# **M3 Junction 9 Improvement**

**Scheme Number: TR010055**

## **8.1 Cover Letter Deadline 1**

**6 June 2023**

DRAWING TITLE
FIGURE 7.3.1 - LANDSCAPE AND VISUAL: LANDSCAPE CHARACTER AREAS APFP REGULATIONS 5(2)(a) DOCUMENT REFERENCE 6.2

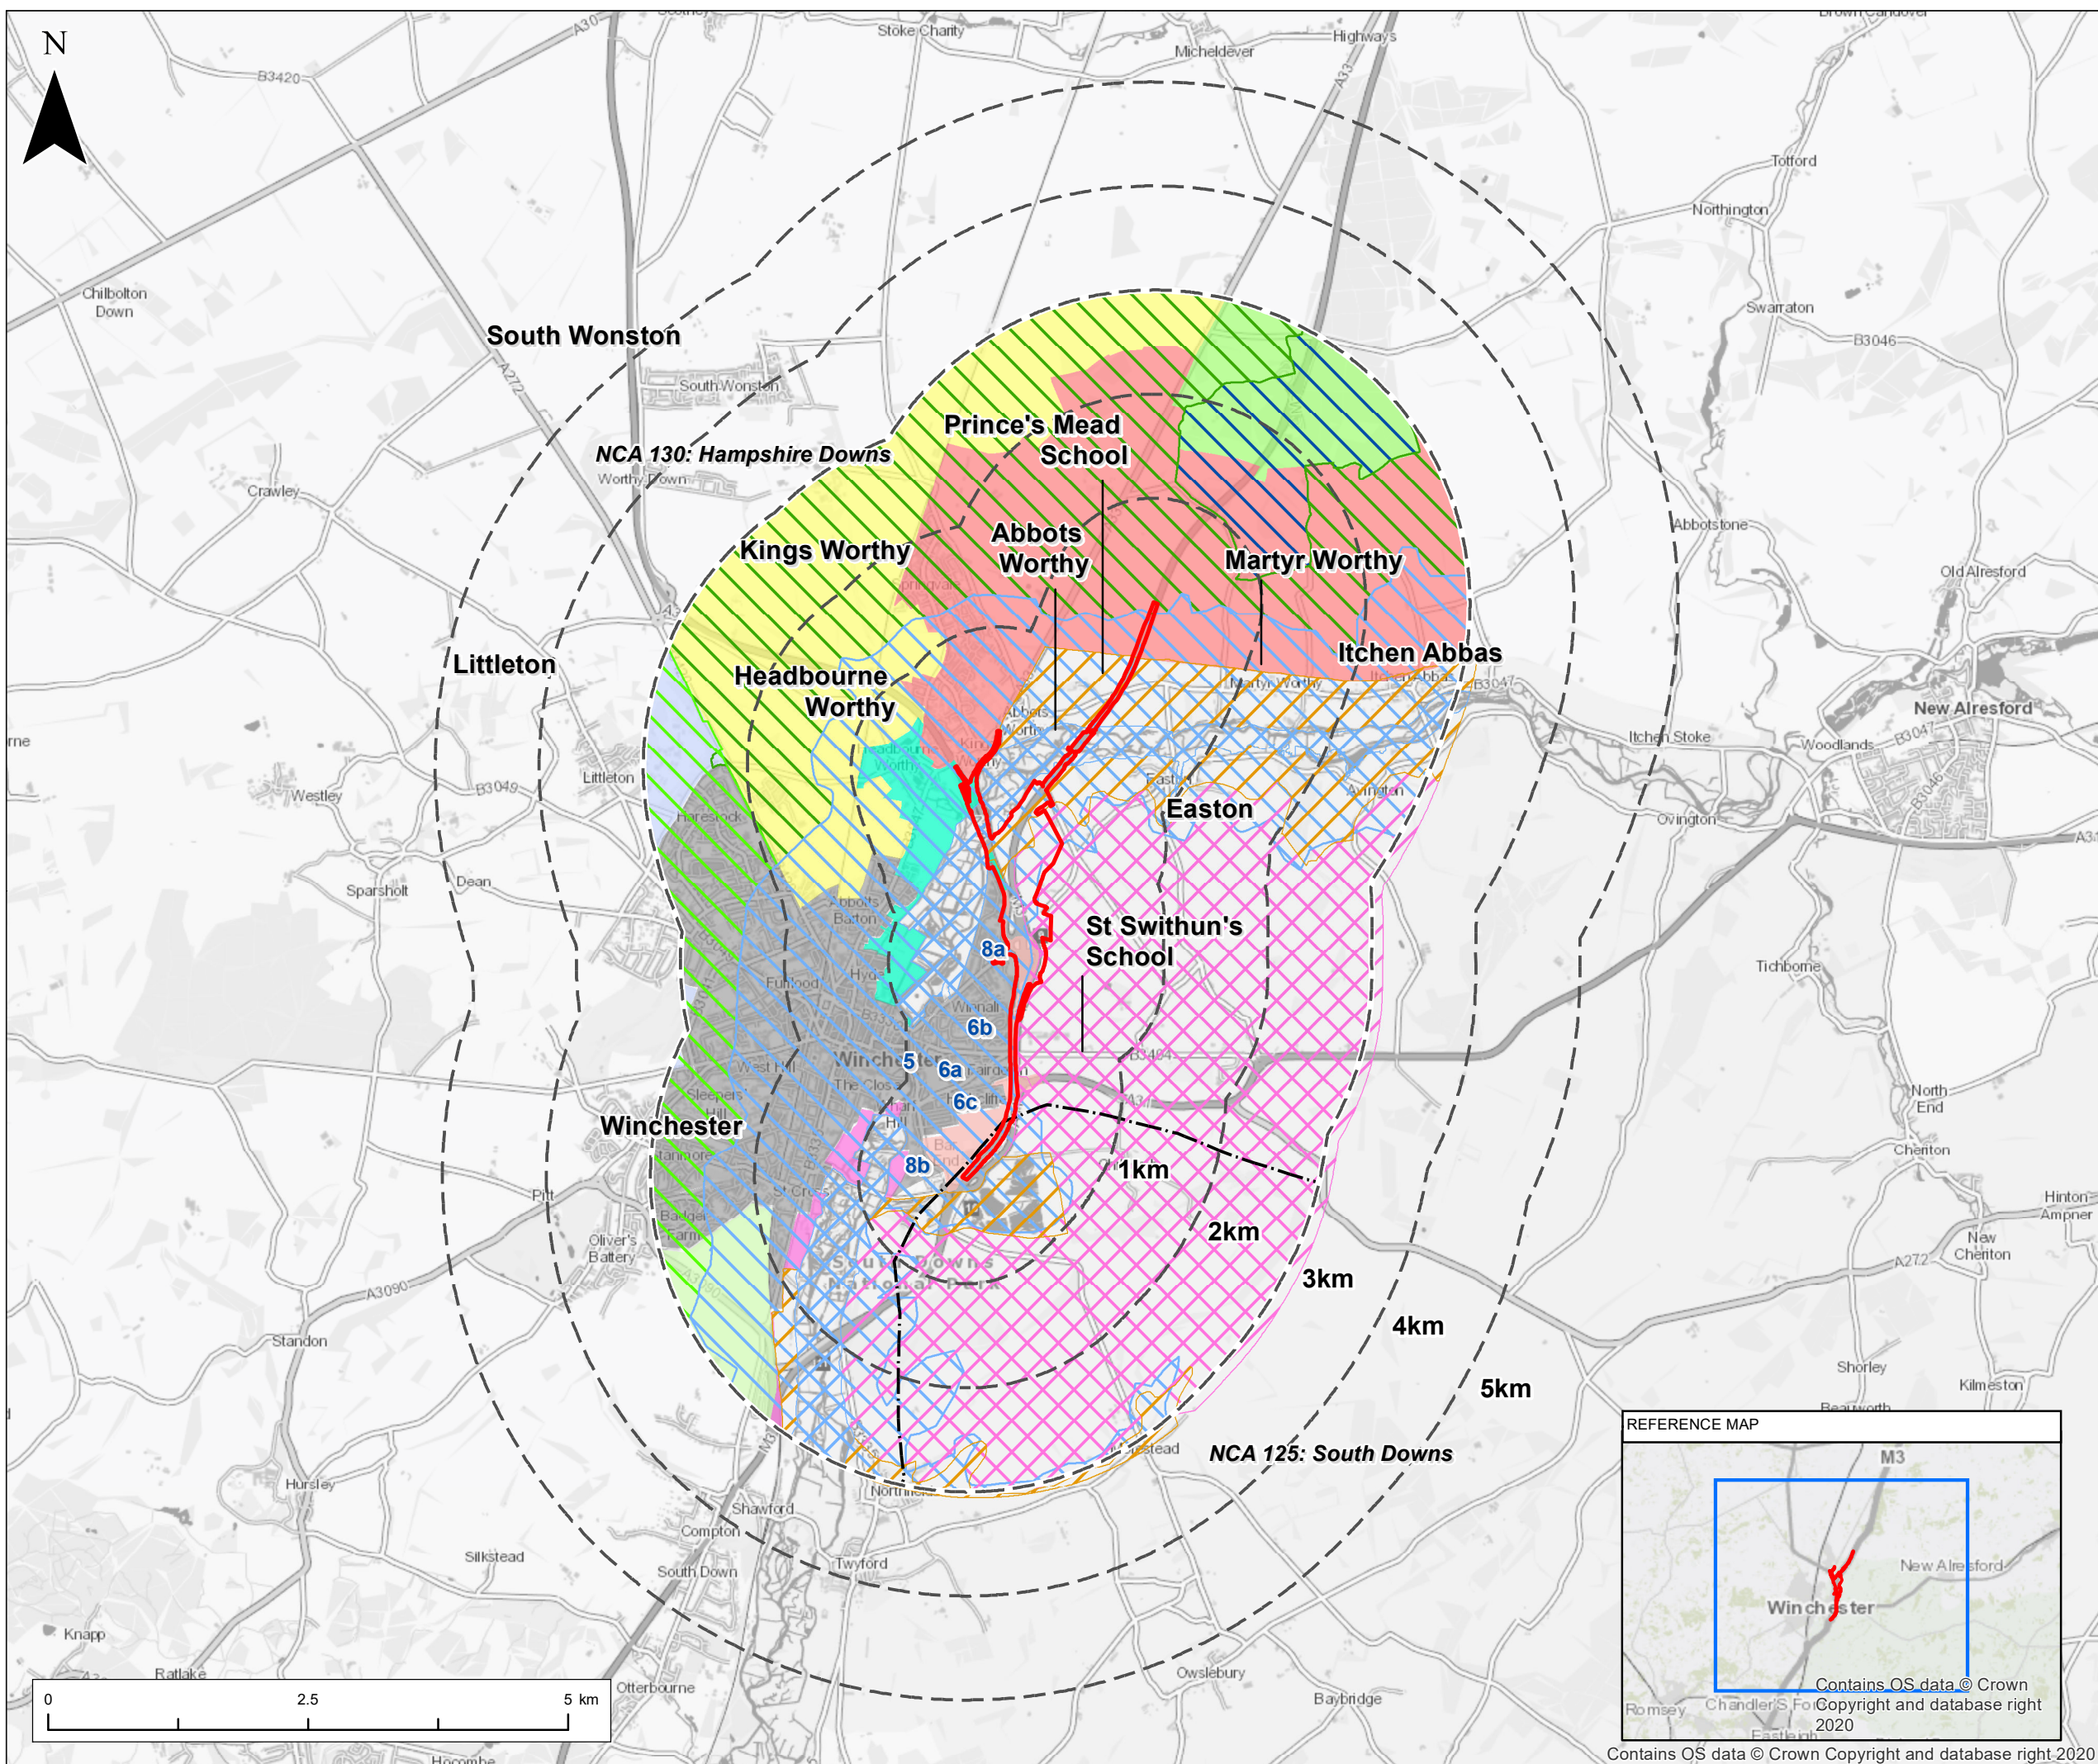
2.5.1 As part of ongoing discussions regarding its Statement of Common Ground (SoCG), Winchester City Council commented that the scope of the landscape and visual assessment should make reference to and consider the updated Winchester City Council Landscape Character Assessment (LCA) Supplementary Planning Document 2022.

2.5.2 These updates result in the addition of new landscape receptors which had previously been discounted in the Application Document submission. Updates have been undertaken to:

- d. **Figure: 7.3.1 (Landscape Character Areas)** contained within **ES Chapter 7 (Landscape) (6.2, APP-067), Figures Part 1 of 3, Figure 7.3.1 Landscape Character Areas, Page 4**. This Figure has been updated for Deadline 1 to include the additional baseline landscape character areas included within the WCC LCA 2022.

**FIGURE 7.14 LANDSCAPE AND VISUAL:VISUALISATIONS - SHEET 26 OF 28**

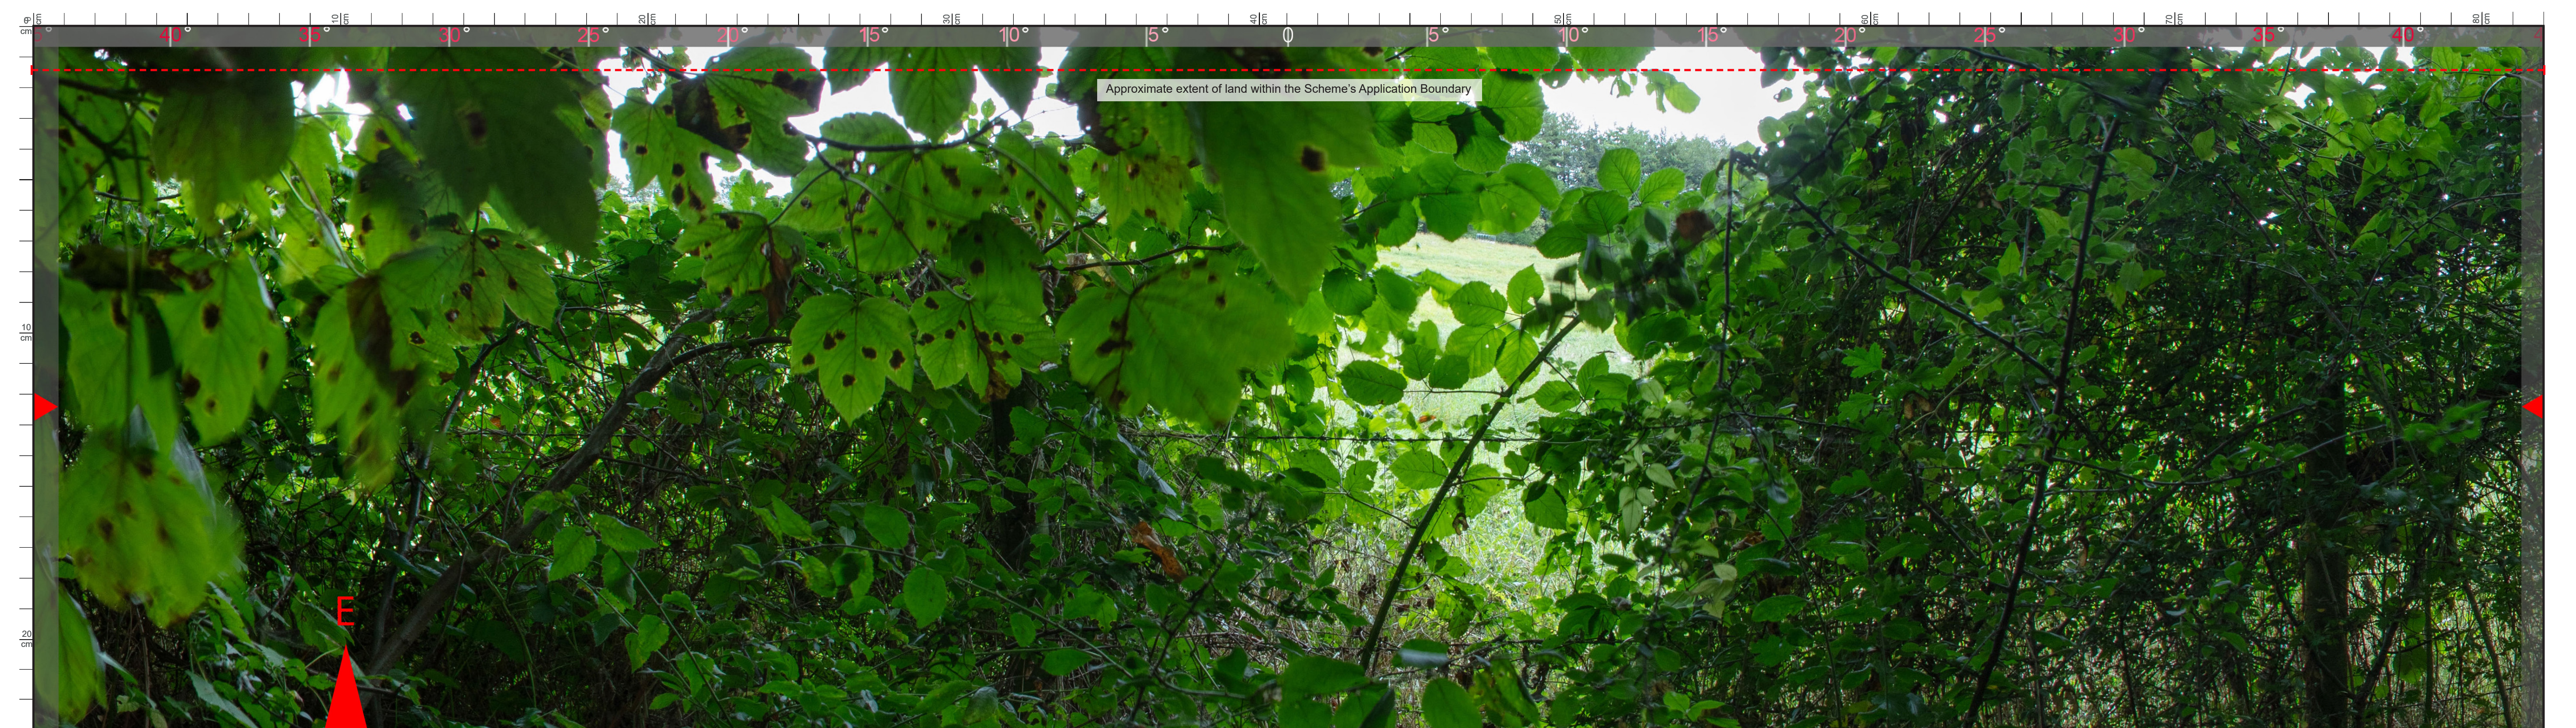
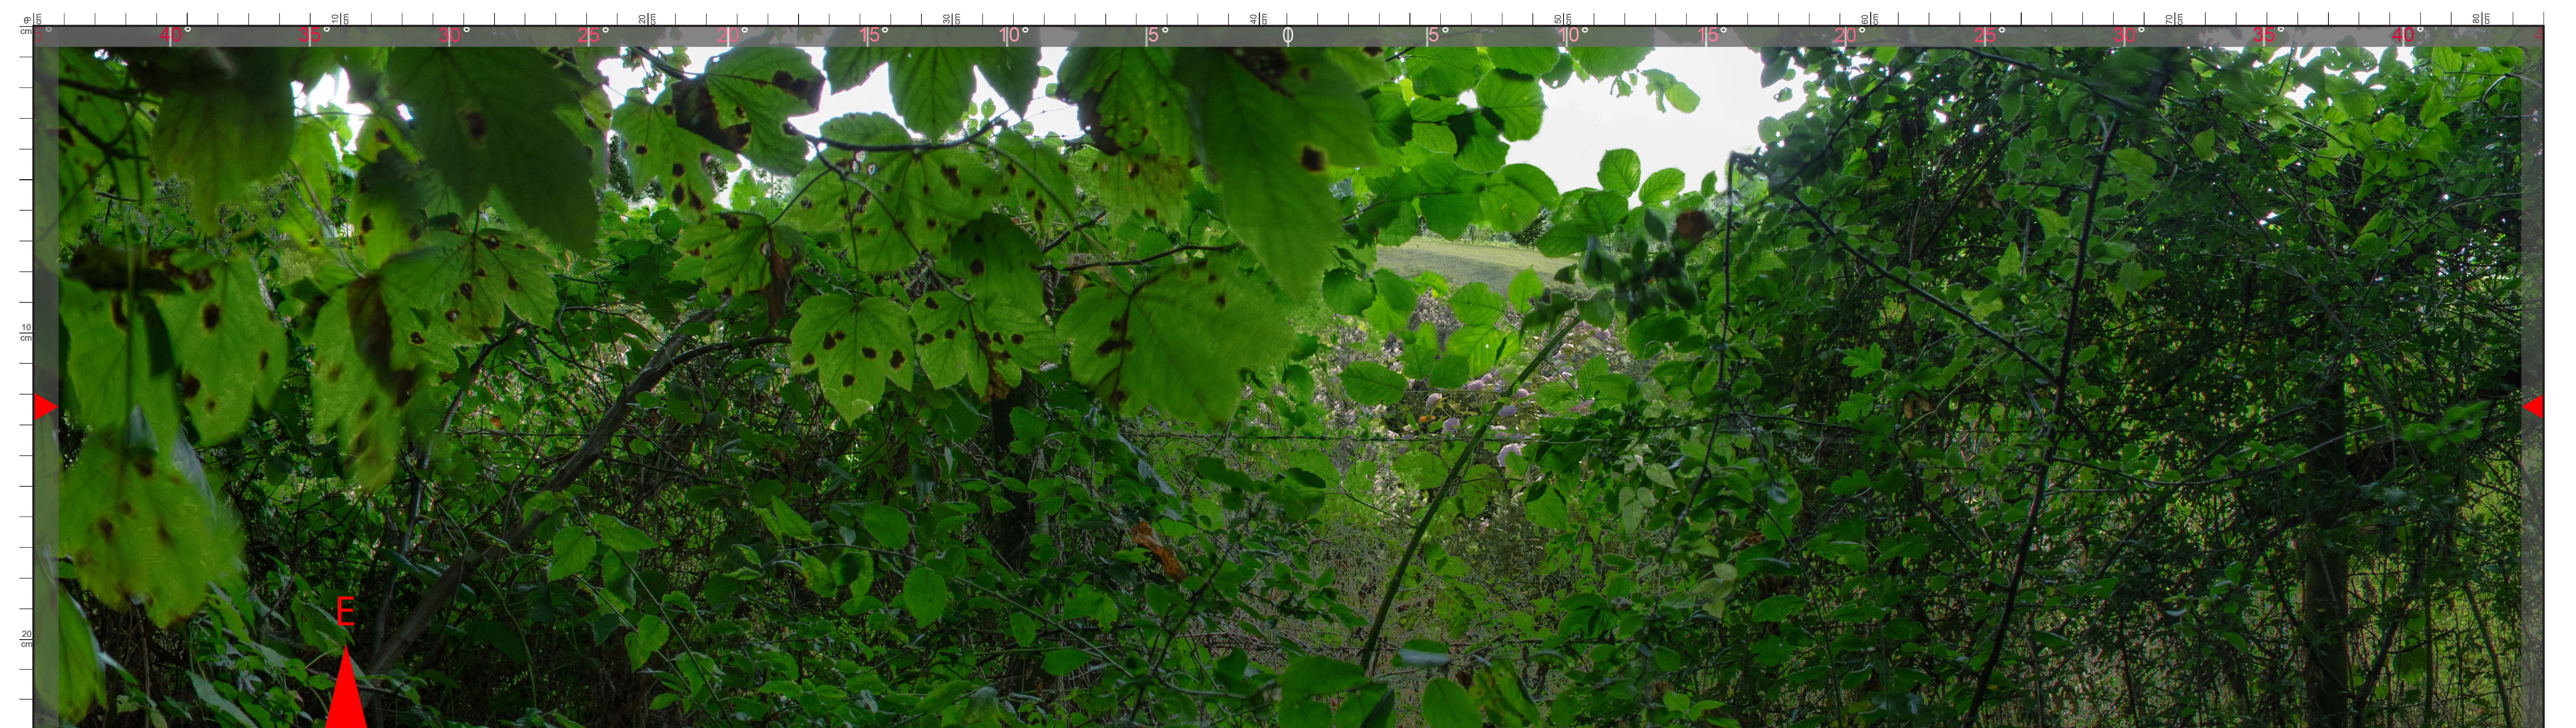
2.5.3 Additional updates have been undertaken in relation to comments received from the South Downs National Park Authority review of **Chapter 7 (Landscape and Visual)** of the **Environmental Statement (ES) (6.2, APP-048)** (comments from Michelle Bolger Expert Landscape Consultancy '1261 R01 M3 Junction 9 Review' on behalf of the South Downs National Park Authority, received 13 April 2023). This resulted in the following updates:

- b. **Appendix 7.3 Schedule of Landscape Effects (6.3, APP-099)**. This is updated to remove chalk grassland as embedded mitigation.
- c. **Figure: 7.14 (Visualisation) - ES Chapter 7 (Landscape) (6.2, APP-069), Figures Part 3 of 3, Figure 7.14 Visualisations, VL 14 Sheets 25 to 28, (Pages 43-46)** Update to VL14 to remove existing vegetation shown incorrectly in the year 1 scenario which will occur as a result of the Scheme.
